**City of Portland, Maine - Building or Use Permit Application**

Job No: 2012-11-5371-ALTR <i>2012 50084</i>	Date Applied: 11/8/2012	CBL: 182- C-004-001	
Location of Construction: 132 WAYSIDE RD	Owner Name: DIRECT REAL ESTATE HOLDINGS, LLC	Owner Address: 66 PEARL ST PORTLAND, ME 04101	Phone: 207-252-7574
Business Name:	Contractor Name: Rob Wing	Contractor Address: 66 PEARL ST PORTLAND MAINE 04101	Phone: 207-252-7574
Lessee/Buyer's Name:	Phone:	Permit Type: Building	Zone: R-3
Past Use: Single family	Proposed Use: Same - Single family - build an <i>20'x22'</i> attached garage. <i>22'x22'</i>	Cost of Work: \$21,000.00	CEO District:
		Fire Dept: <input checked="" type="checkbox"/> Approved <i>w/conditions per Ct. Wallace</i> <input type="checkbox"/> Denied <input type="checkbox"/> N/A	Inspection: Use Group: <i>R3</i> Type: <i>SB</i> <i>IRC, 2009</i> <i>MUBEC</i> Signature: <i>[Signature]</i>
Proposed Project Description: New Attached Garage <i>20'x22'</i> <i>22'x22'</i>		Permit Activities District (P.A.D.)

has permission for an addition of 22' by 22' attached garage (Single Family Residence).

## **Conditions of Approval:**

4' frost walls
6" slab
10" footing To Be
Tie in To Existing Foundation

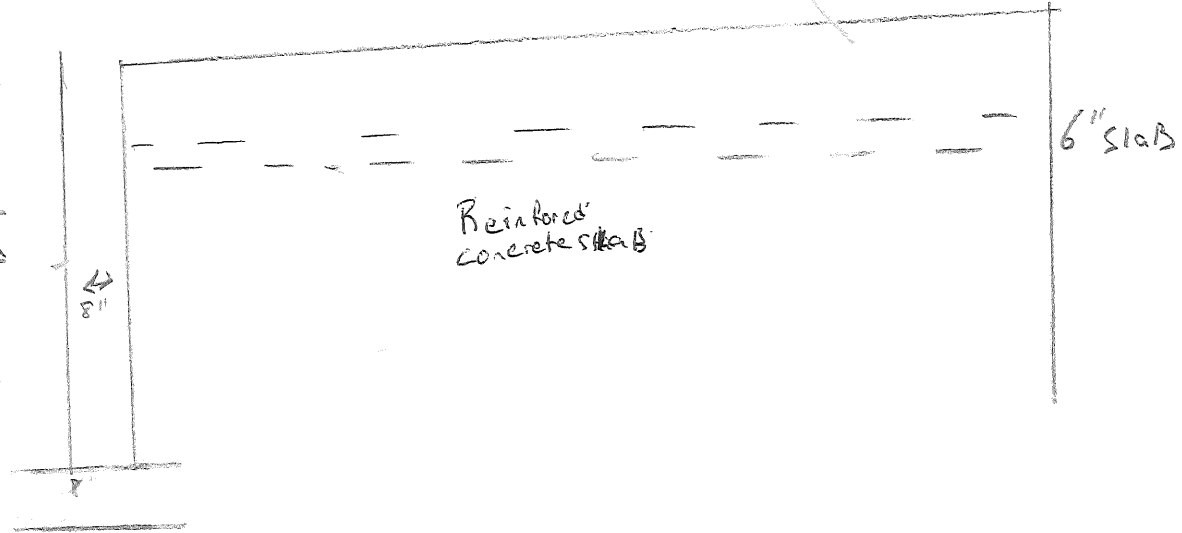
2. Frost protection must be installed per the enclosed detail as discussed w/owner/contractor (at least 4' from grade).
3. Section R317 Protection of Wood and Wood Based Products against decay. All wood framing members that rest on concrete or masonry exterior foundation walls and are less than 8 inches from the exposed ground.

New Door To Be installed For Entry

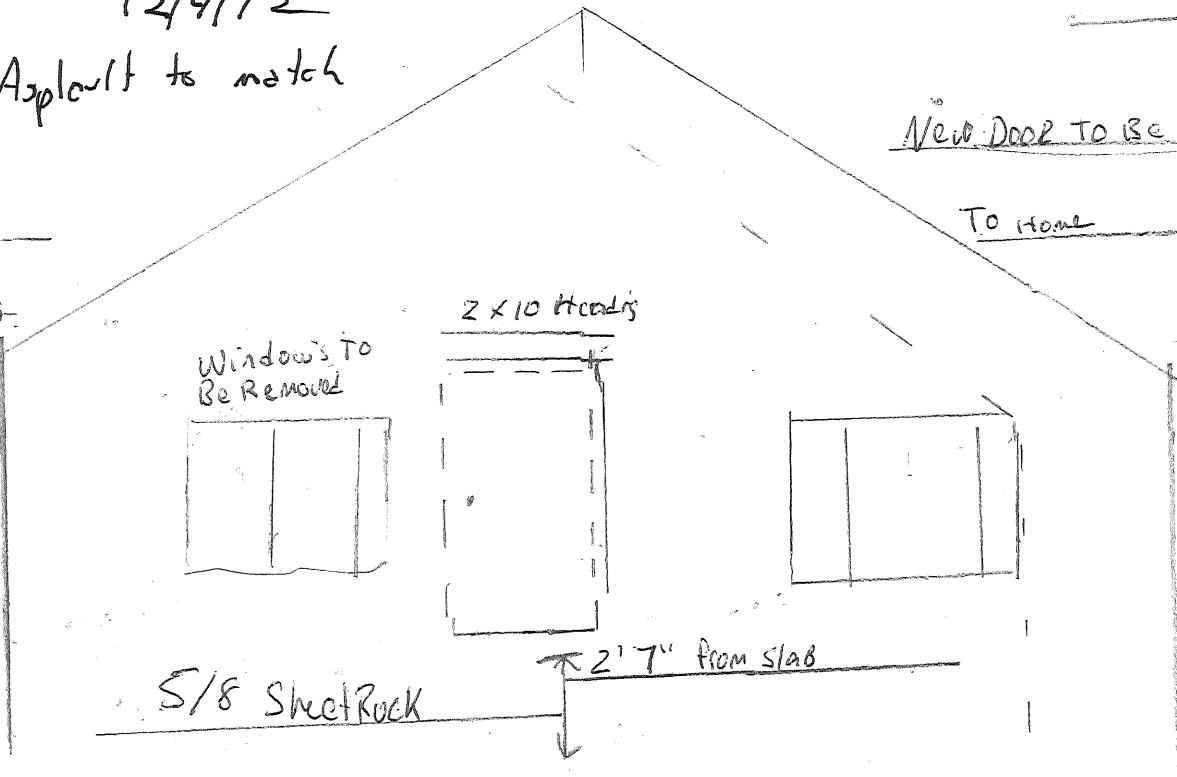
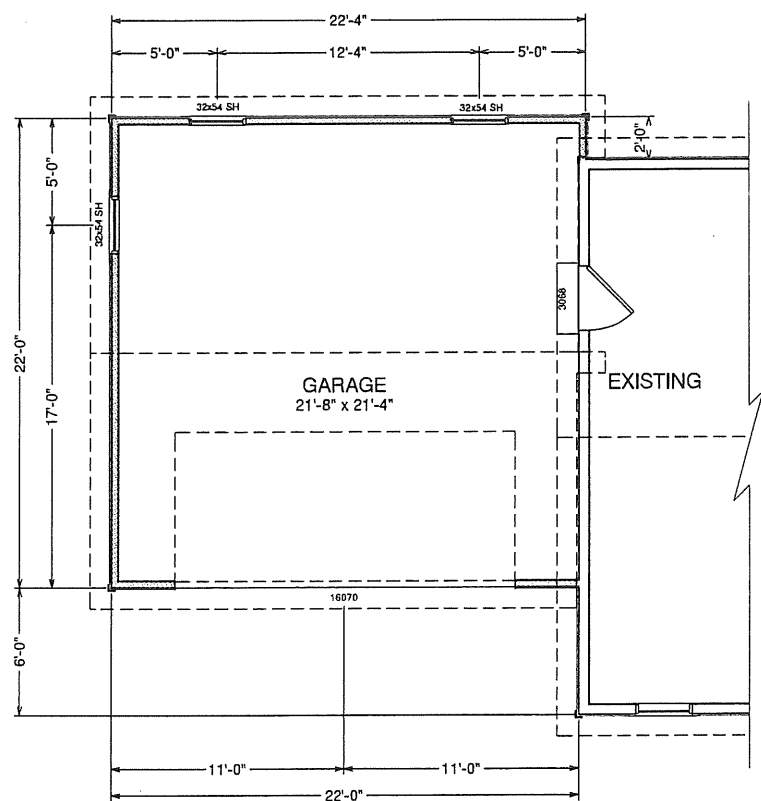
6. The door opening between the garage and residence shall be equipped with solid wood doors not less than 1 3/8" inches in thickness, solid or honeycomb core steel doors not less than 1 3/8 inches thick, or 20-minute fire-rated doors.
7. Note: Submit specifications for engineered trusses & beams to this office prior to construction.
